From: hda projects [REDACTED]
Sent: 12 December 2017 15:13
To: Simon Davis
Subject: RE: AW/306/17/HH - 4 Apple Grove

From: Simon Davis
Sent: 12 December 2017 11:43
To: 'hdaprojects'
Subject: AW/306/17/HH - 4 Apple Grove

First Floor Plan

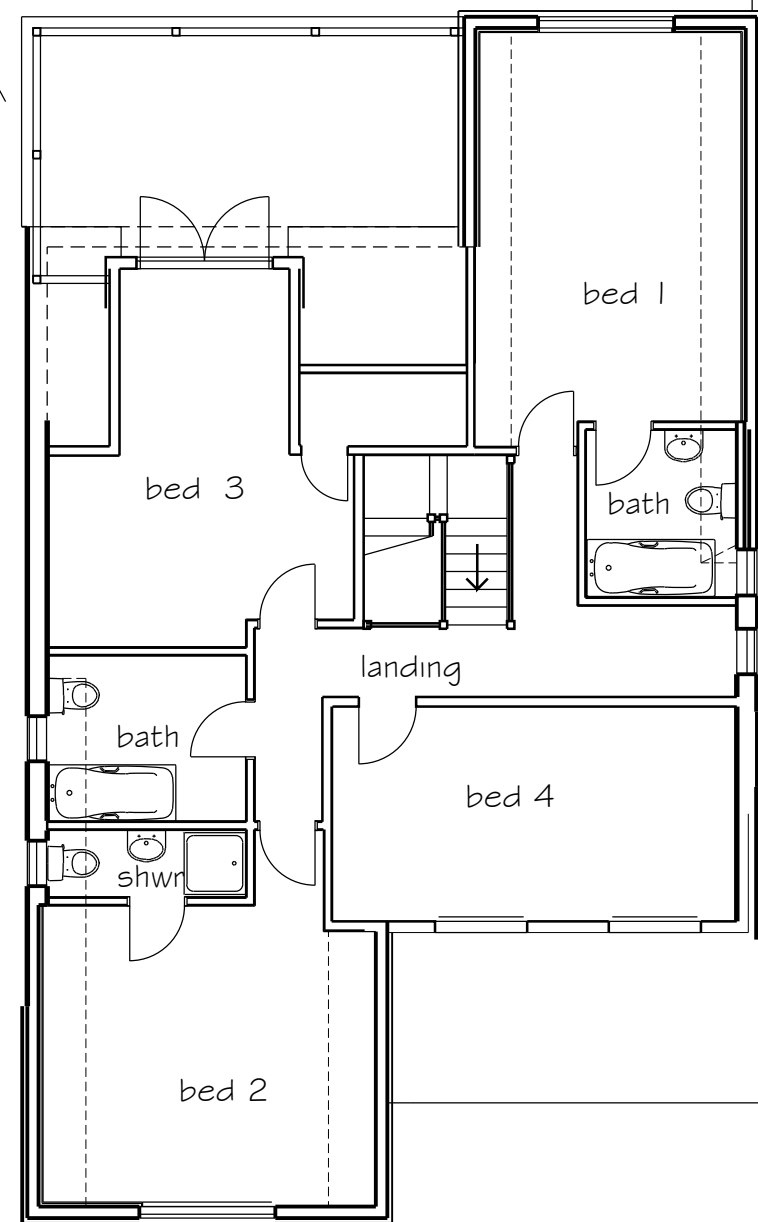
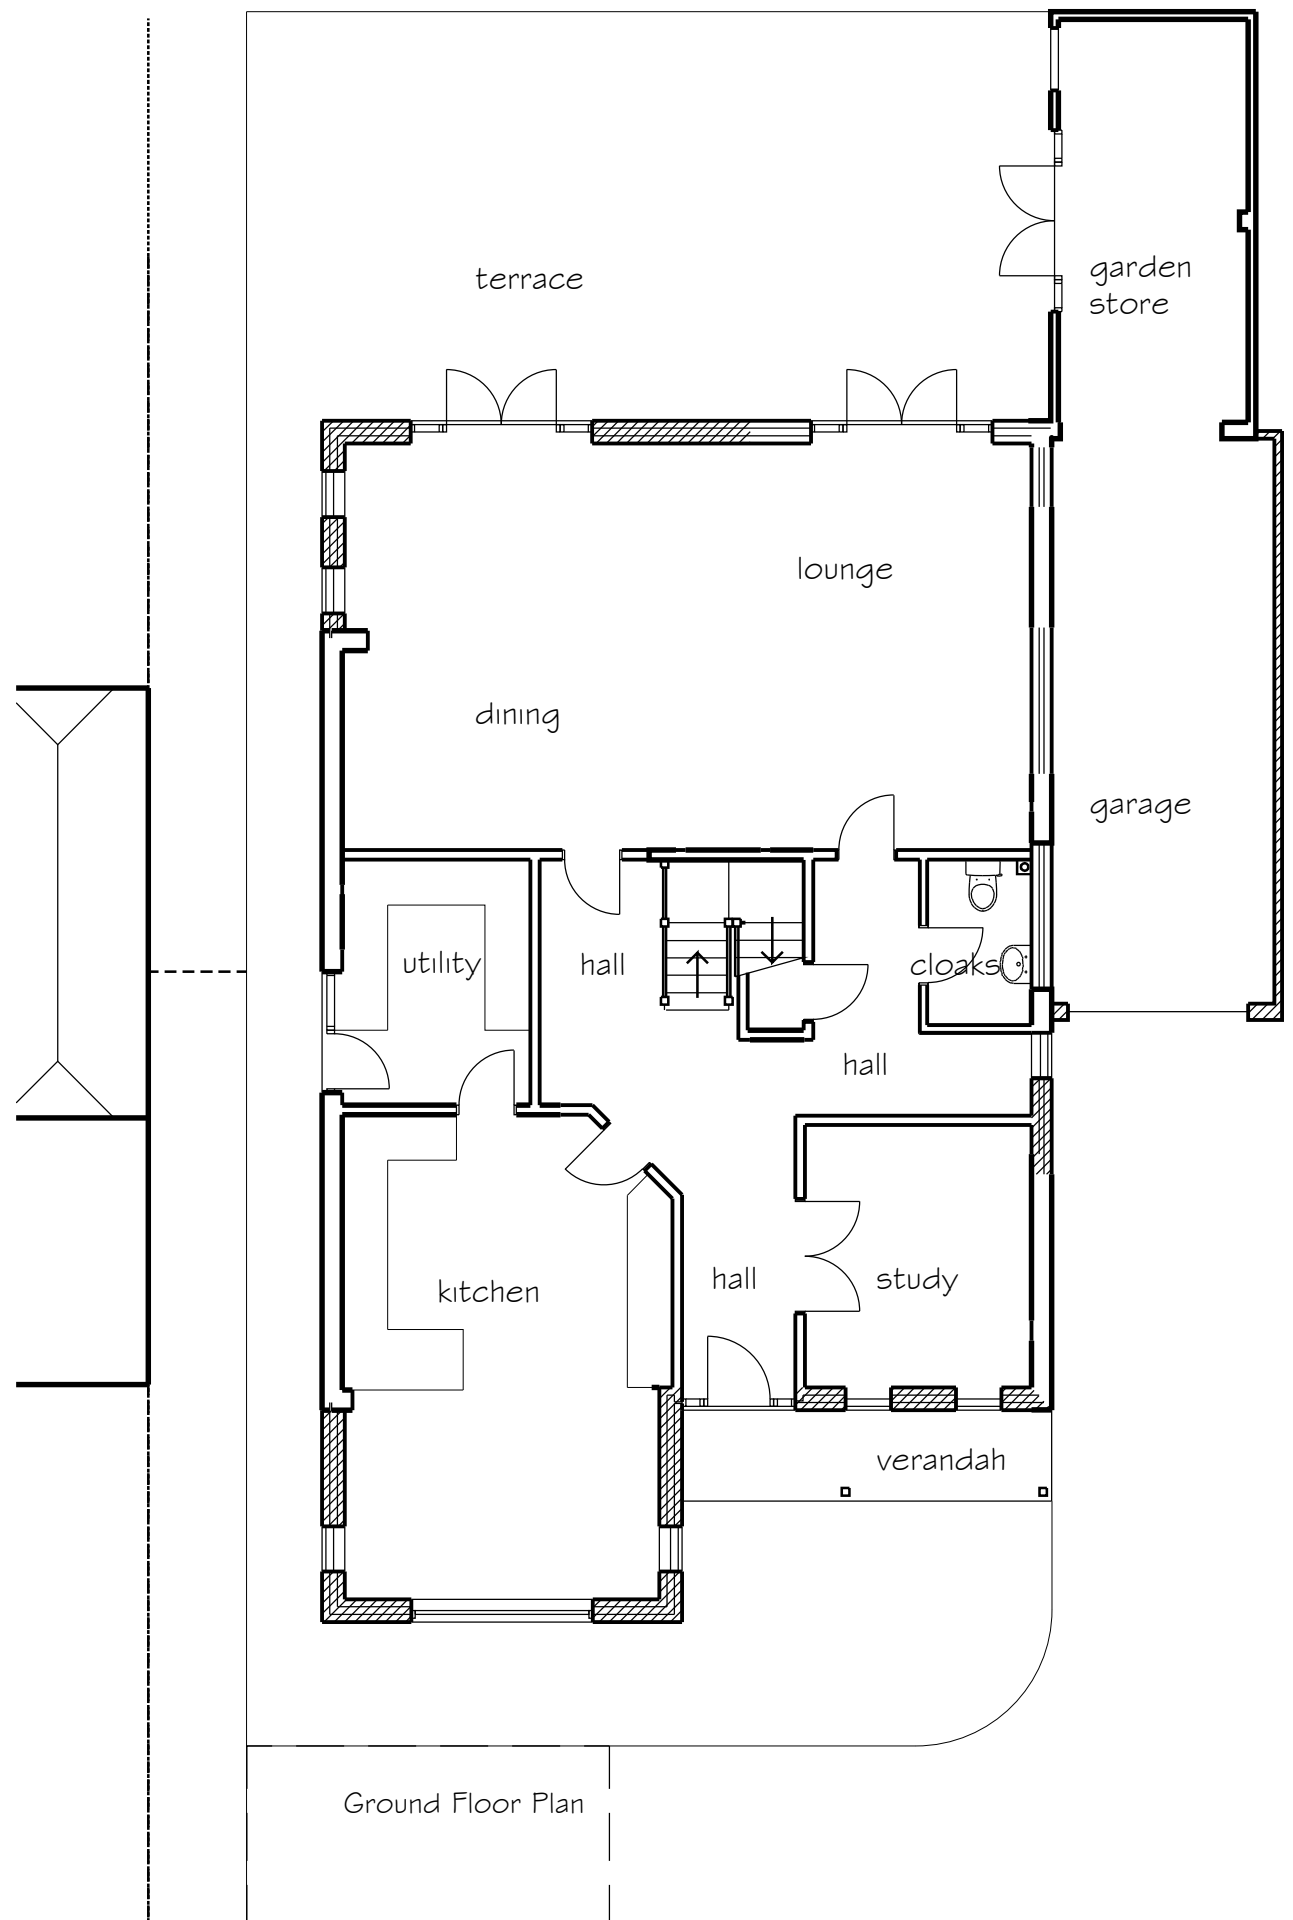
I have today spoken to the applicant (she rang me) and told her I will be approving this sometime in January. I mentioned to her that I would need an amendment in respect of the side of the balcony facing no. 5. I need you to amend the drawings to show a 1.8m high obscure glazed or solid side screen to this side of the balcony. Are you able to do this?
